From: [REDACTED]
Sent: 12 May 2022 12:20
To: Planning
Subject: Planning Application No. 3/2022/0357

Regarding the proposed construction of Garage and Extension of Existing Garden Room.2 Bowland View.

**Proposed Garage & Garden
Room Extension
at
2 Bowland View
Gisburn
for
Mr A Parkinson**

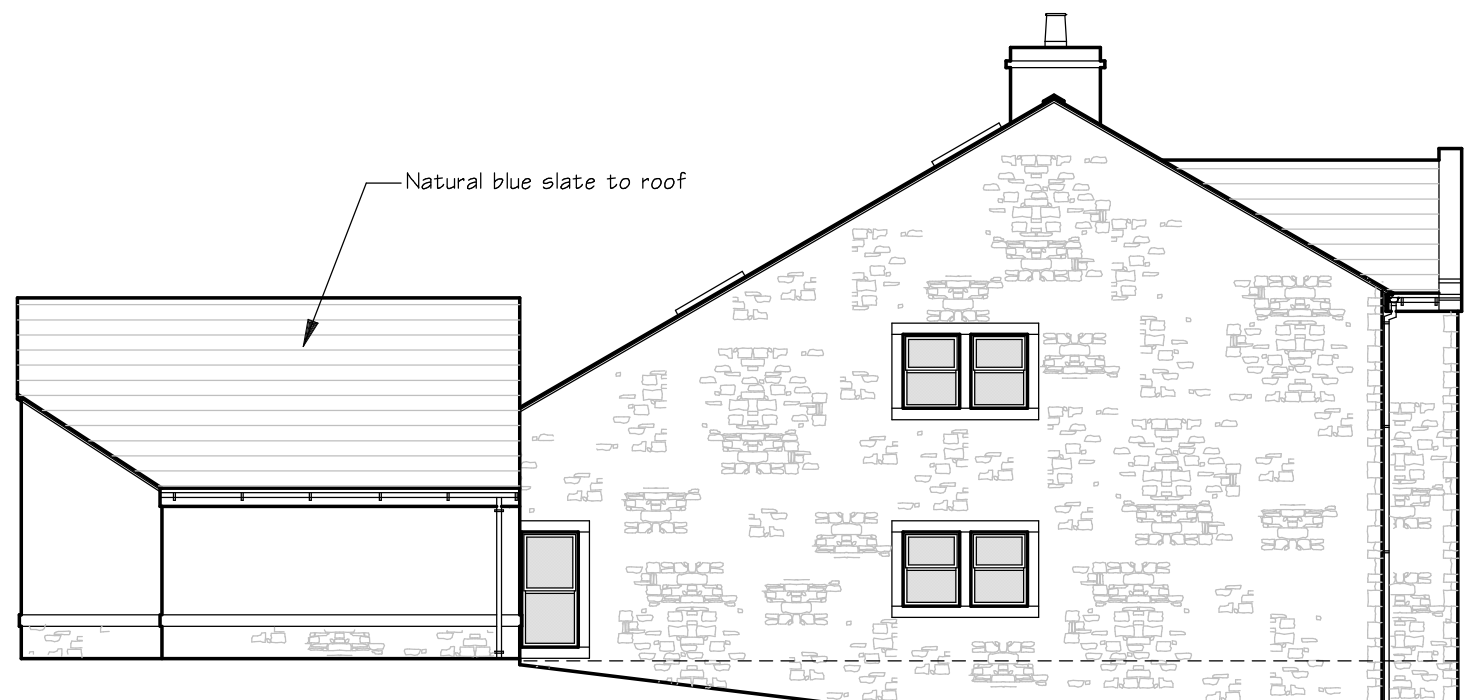
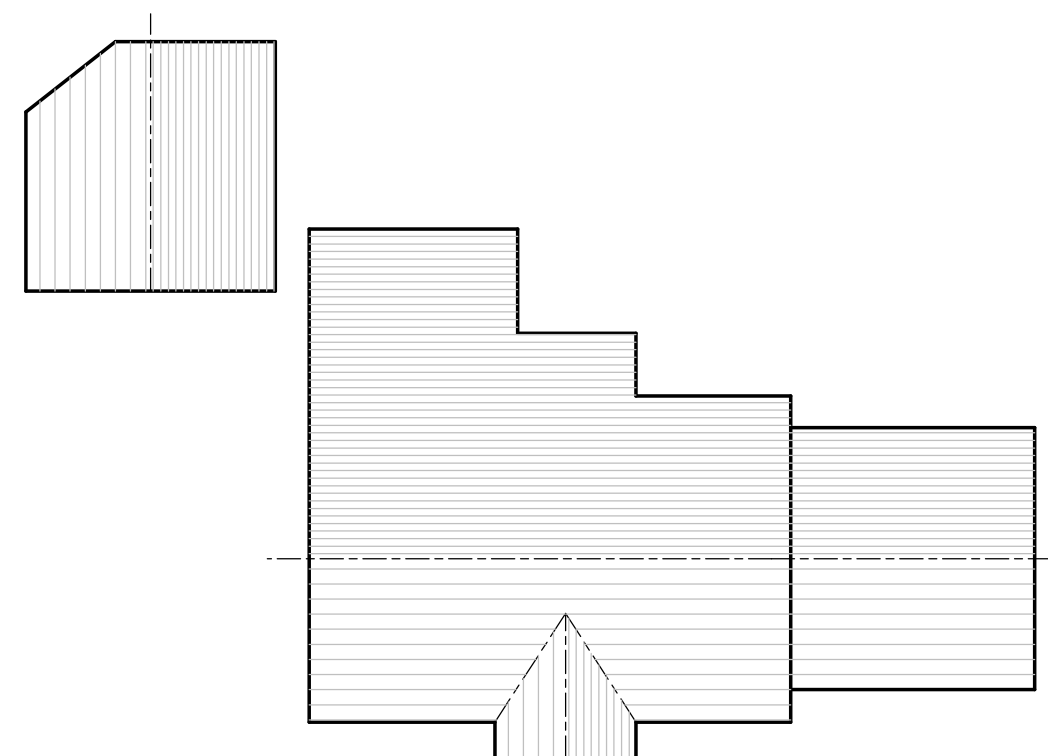
- The Garden Room Extension is not in keeping with the Existing Garden Room ie the Roof does not have the same Hipped Roof Construction. (All the properties on the development have Hipped Roof Construction) In stead the plans show a towering K rendered gable end that is visible from [REDACTED]

- Despite already having a Large Double Garage the proposal shows an additional Garage complete with personal door access and additional 2 windows.

All sides to be k rendered in what can only be described as a Cornish Ice Cream colour!

Proposed Garage & Garden
Room Extension
at
2 Bowland View
Gisburn
for
Mr A Parkinson

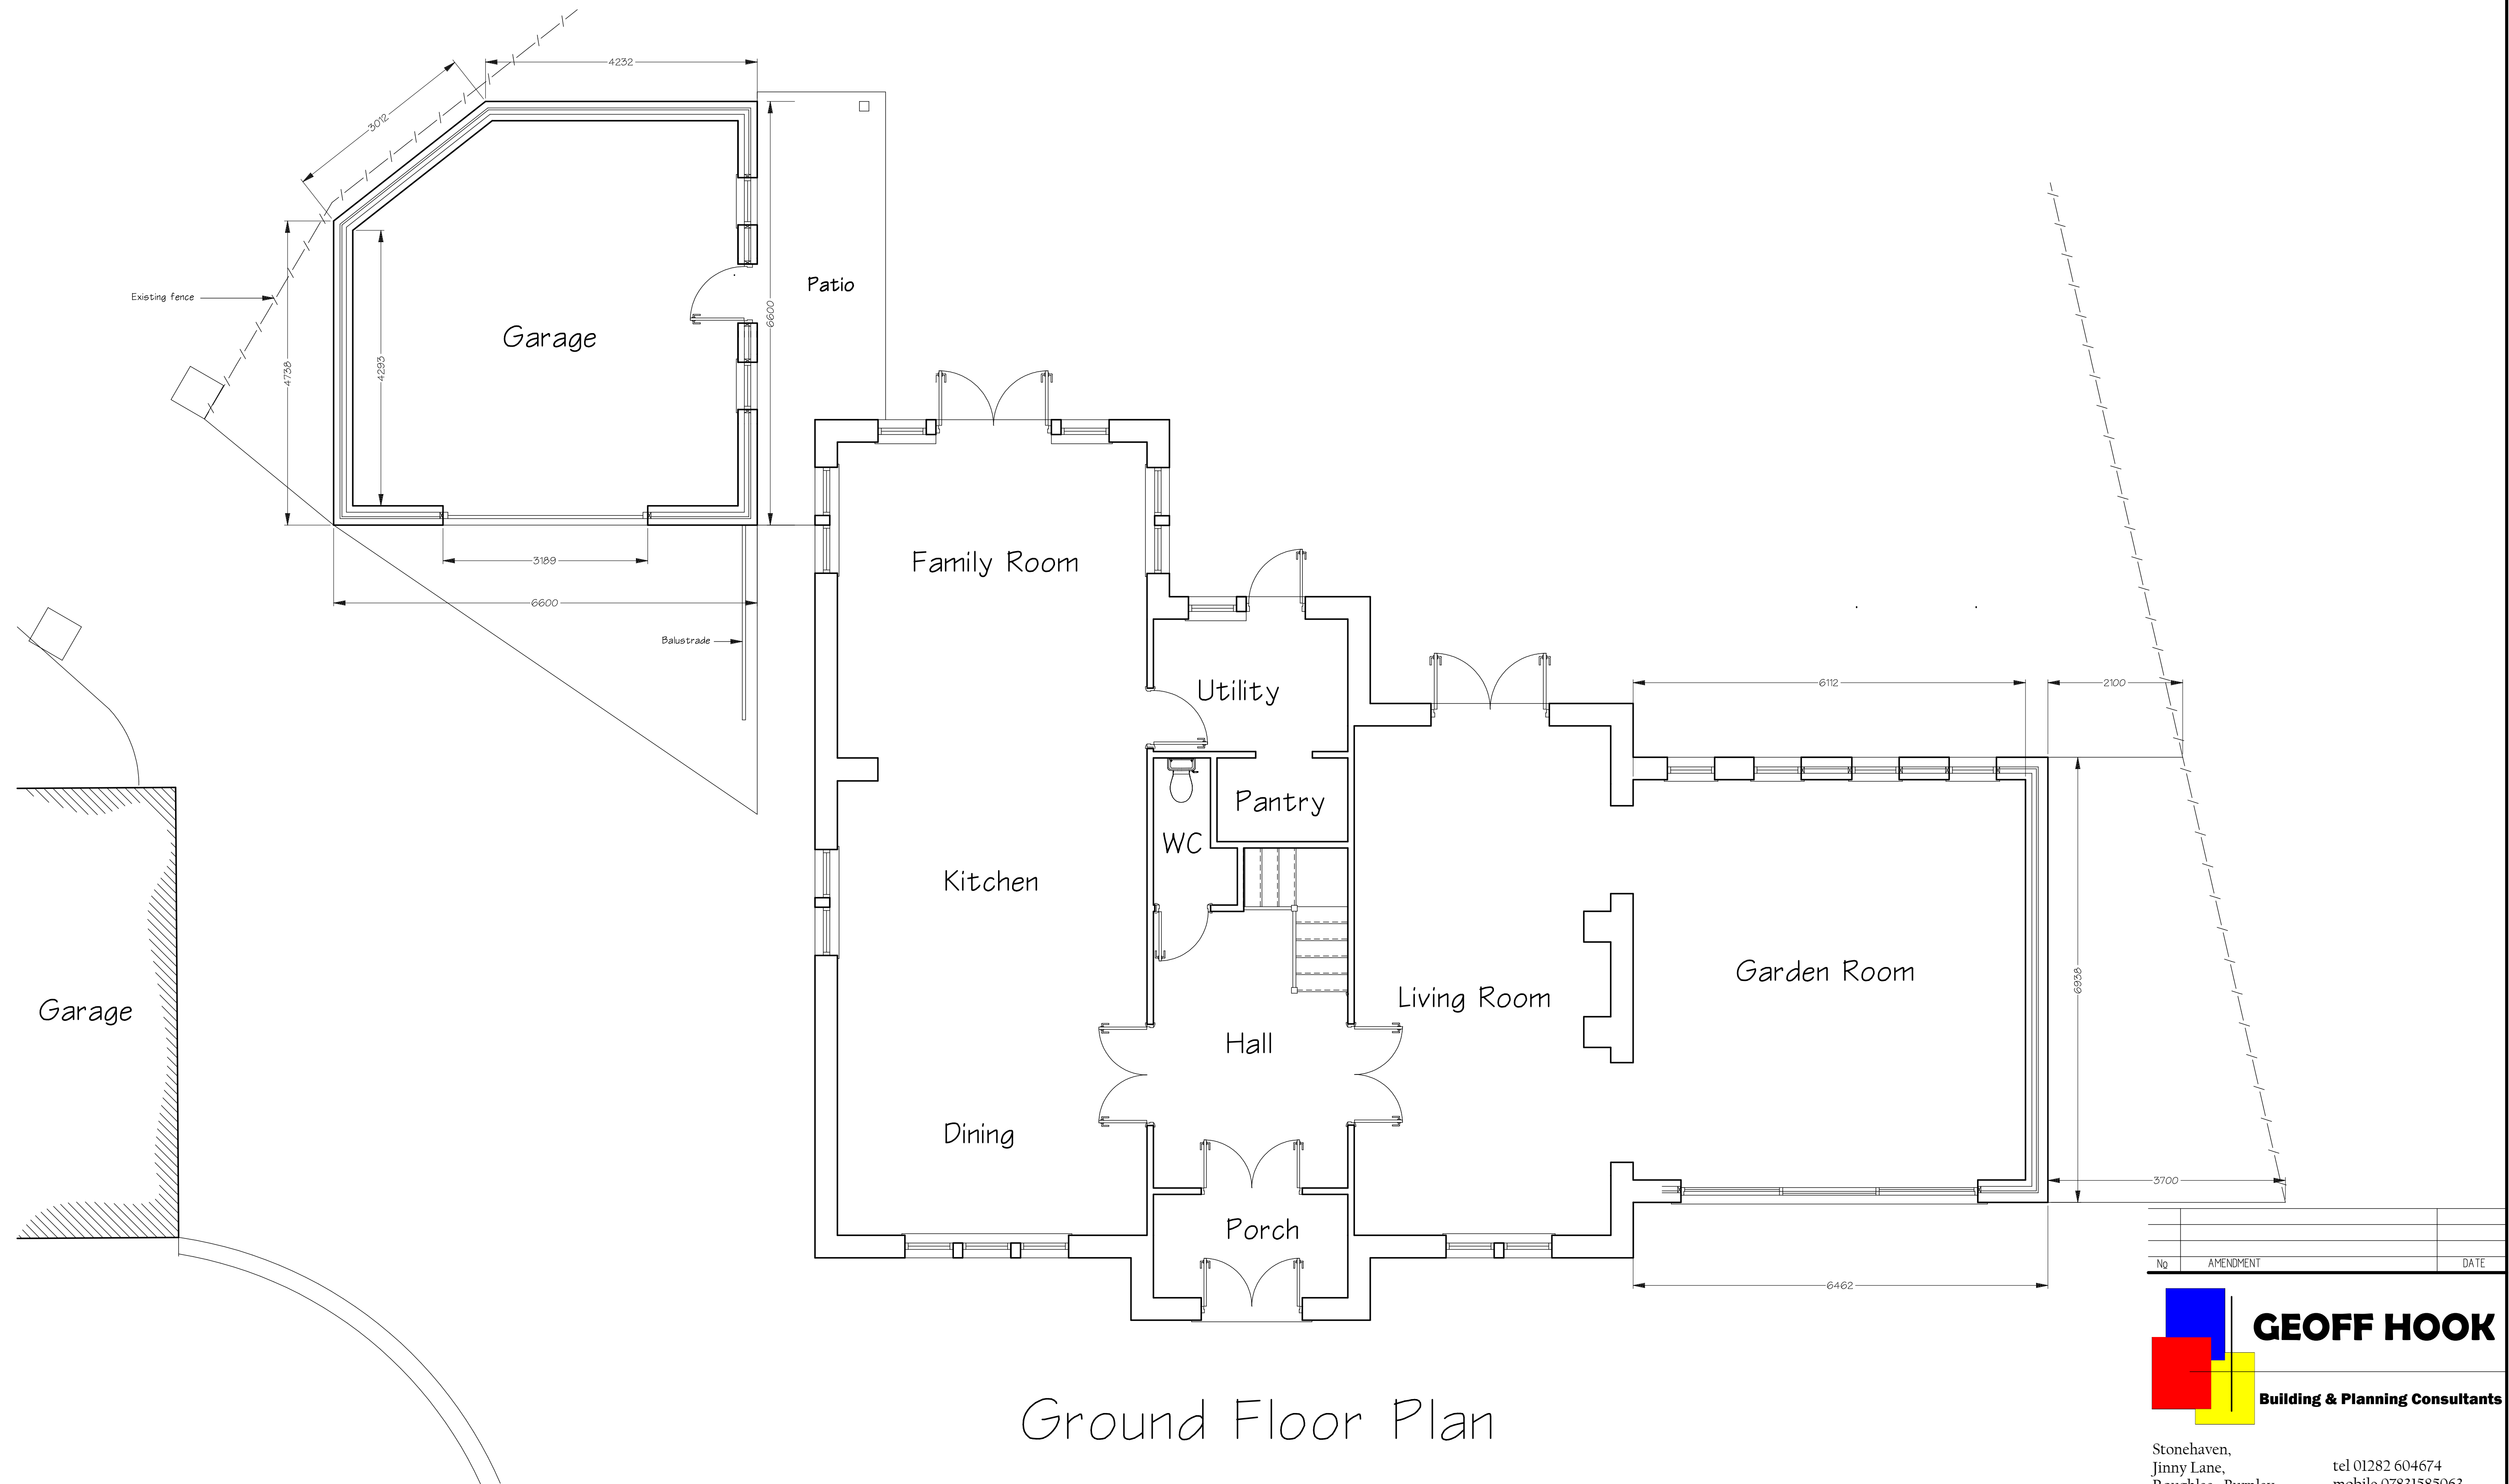
- The Proposed Garden Room and Garage are both in what is already a Very Small Back Garden.(2 Bowland View has the smallest plot on the development)

- 2 Bowland View already has a small Drive Way restricting parking and the ability to turn vehicles around. The Addition of another Garage would limit off road Parking.
